# Rezoning Transportation Analysis

Petition Number: 2020-132

General Location Identifier: Tax ID (02911104)

Date	Description
10-22-20	First Review (EL)
11-30-2020	Second Review (KP)

SHEET NUMBER: RZ-1.0

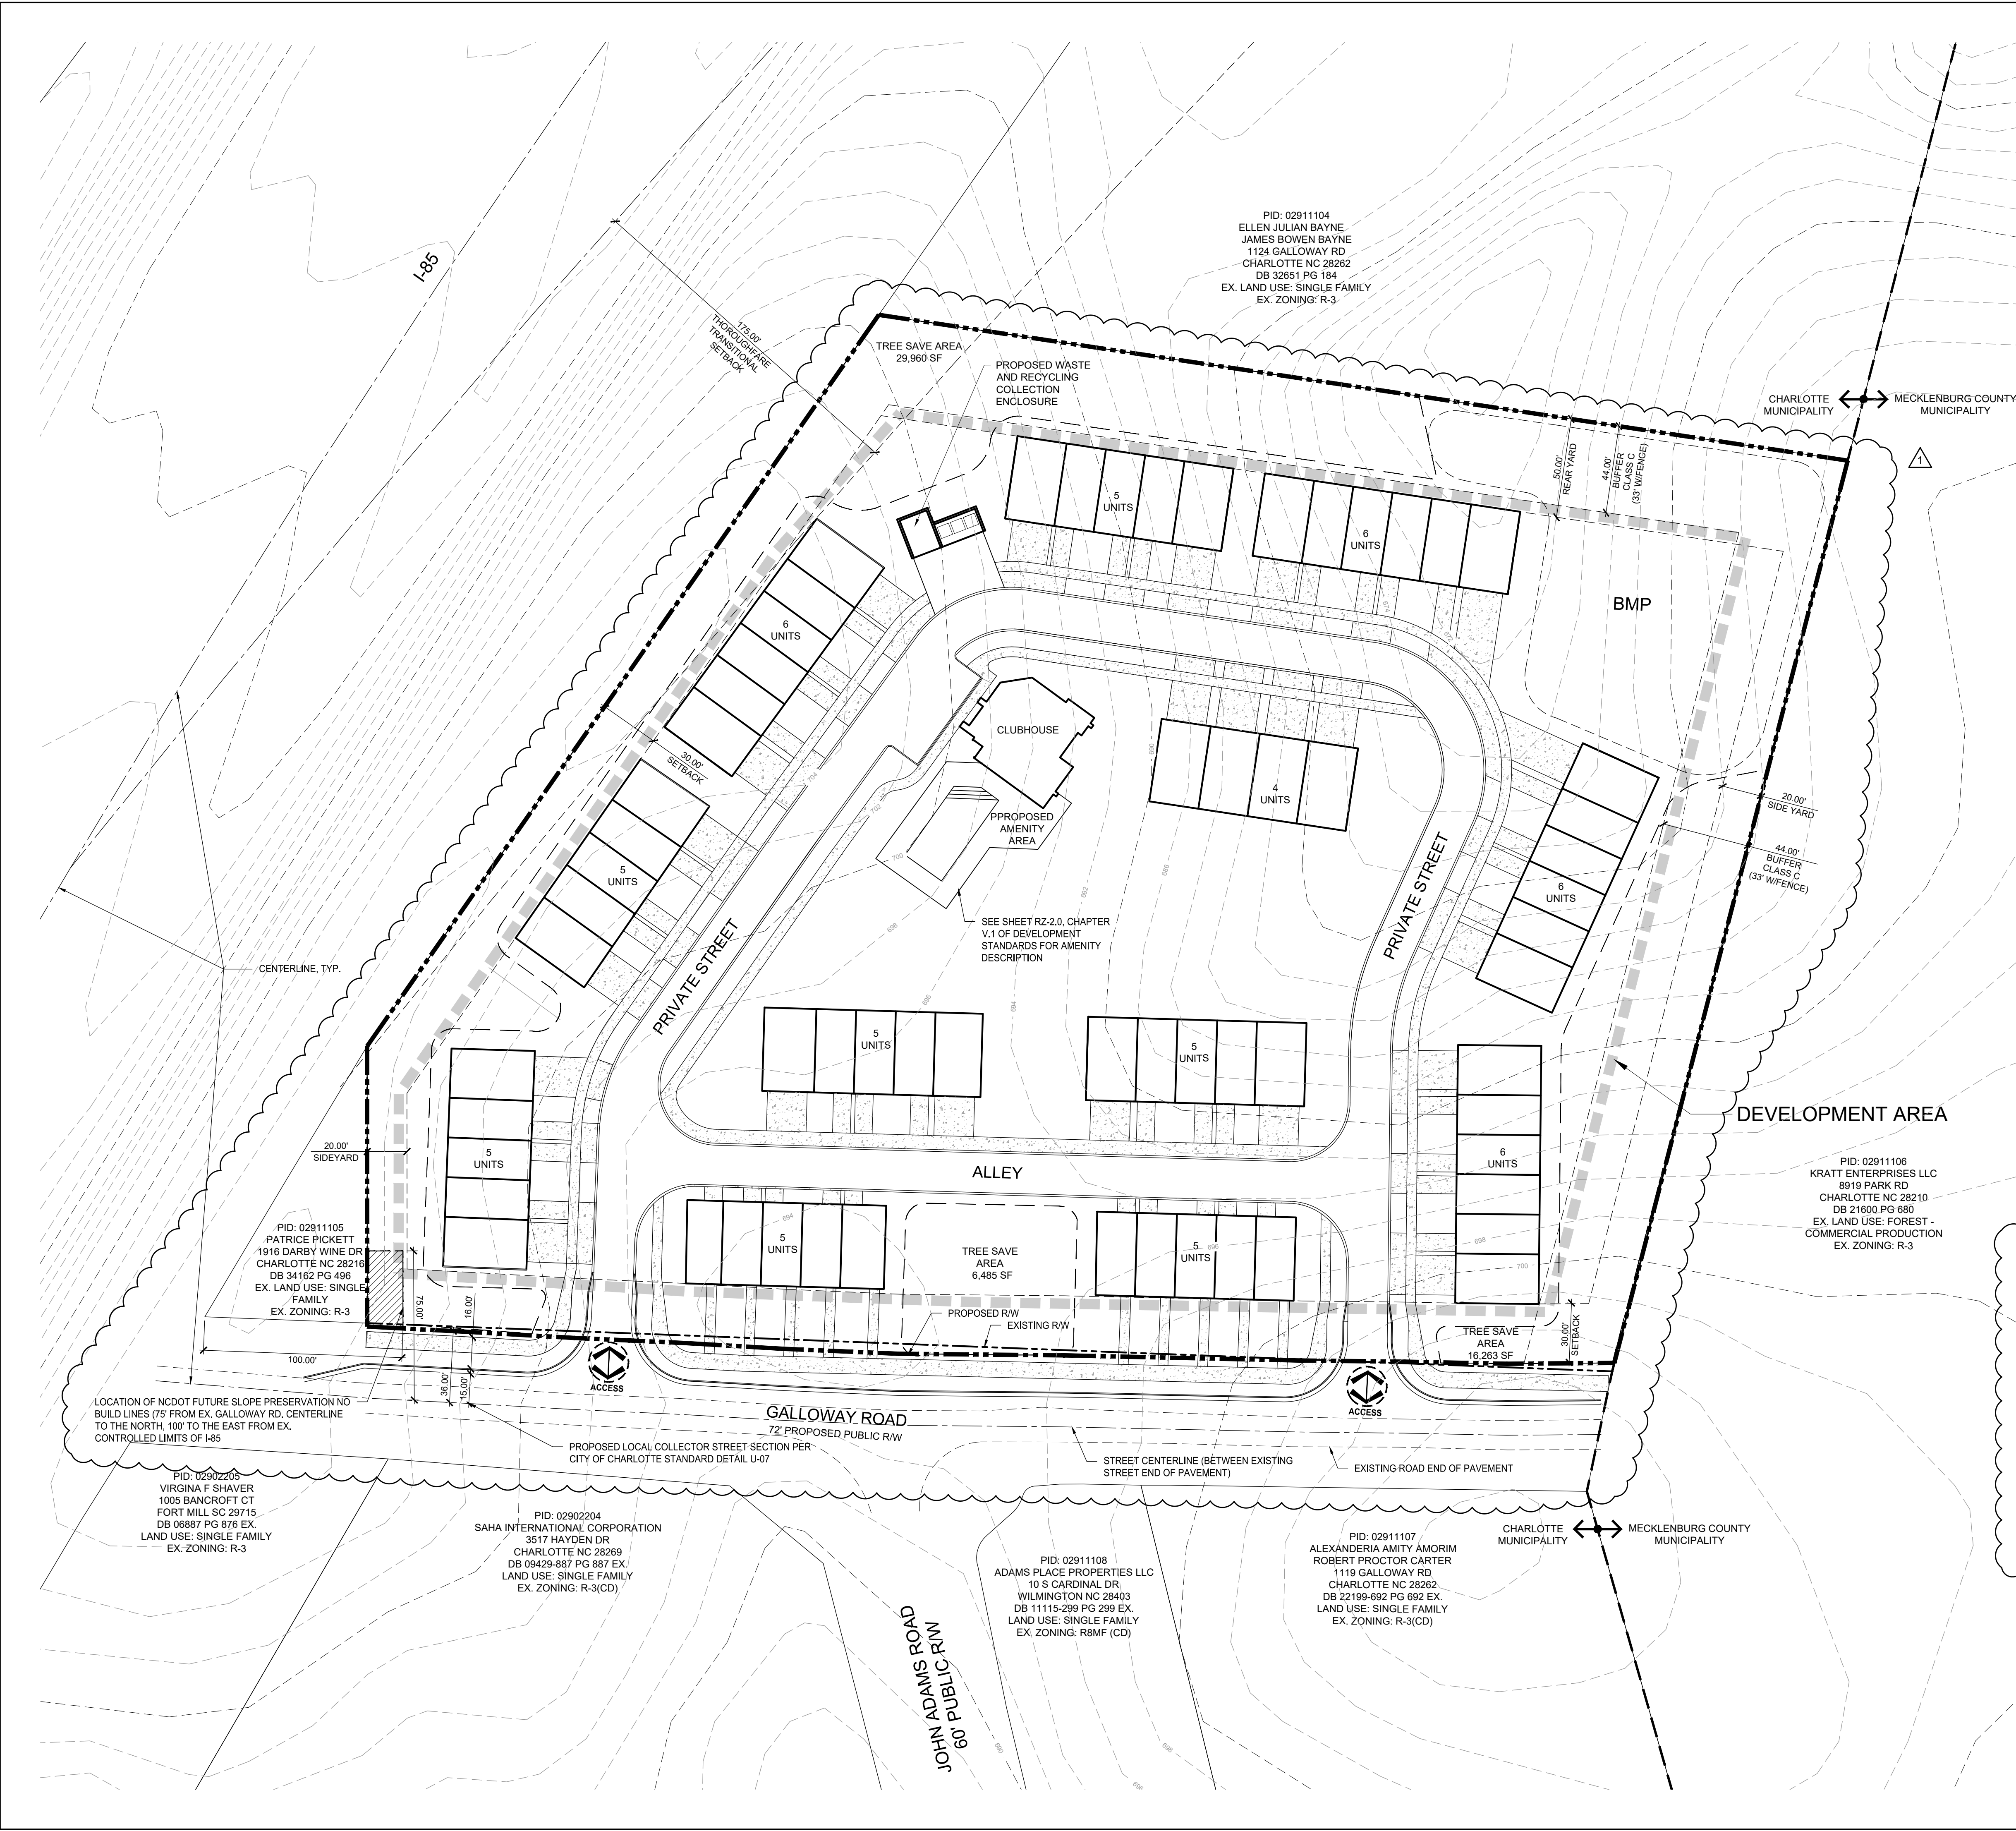
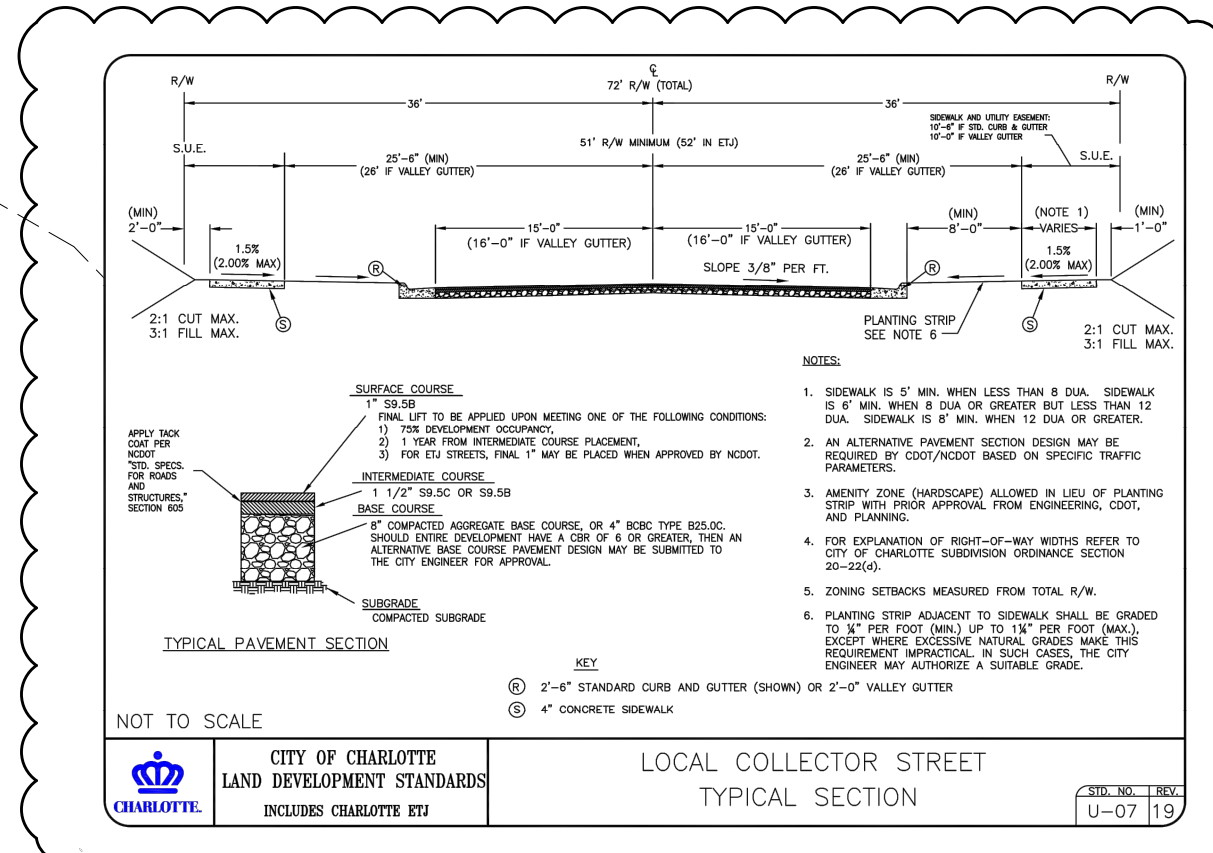
- a. ~~Galloway Road: Location of curb and gutter needs to be installed 15 feet from road centerline, to match the collector street cross section that will be constructed within the following approved land development subdivisions: **SDRMF-2018-00082 – Selburn Apartments** and **SDRMF-2018-00071 – Galloway Park**. Refer to Charlotte Land Development Standards Manual (CLDSM) std. no. U-07 – Local Collector Street Typical Section. CDOT requests the complete curb and pavement section to be constructed, due to the existing condition of Galloway Road.~~

~~Label and dimension curb and gutter from the centerline for each road.~~

3. ~~Revise site plan and conditional note(s) to commit to dedicate 36-feet of right-of-way from the road centerline, labeled and dimensioned from the road centerline.~~

- ~~4. Revise site plan and conditional note(s) to commit to construct an 8-foot planting strip, and 8-foot sidewalk on Galloway Road as per Chapter 19 / Chapter 20. Label and dimension both items from the back of curb and gutter and road centerline.~~
- ~~5. The proposed dwelling units exceeds 12 per acre. Per Chapter 20 Subdivision ordinance, site plan and conditional note(s) revisions are needed to commit to construct an 8-foot planting strip, and 8-foot sidewalk along Galloway Road. The wider sidewalk also meets the Charlotte WALKS Policy.~~

- ~~6. Revise the site plan and conditional note(s) to commit to reserve 100 feet to the east of the existing controlled access limits of I-85 and 75 feet to the north of the existing Galloway Road centerline to establish a slope preservation for a future I-85 bridge crossing. Refer to the site plan and conditional notes within rezoning petitions 2016-139 and 2017-150 for reference.~~
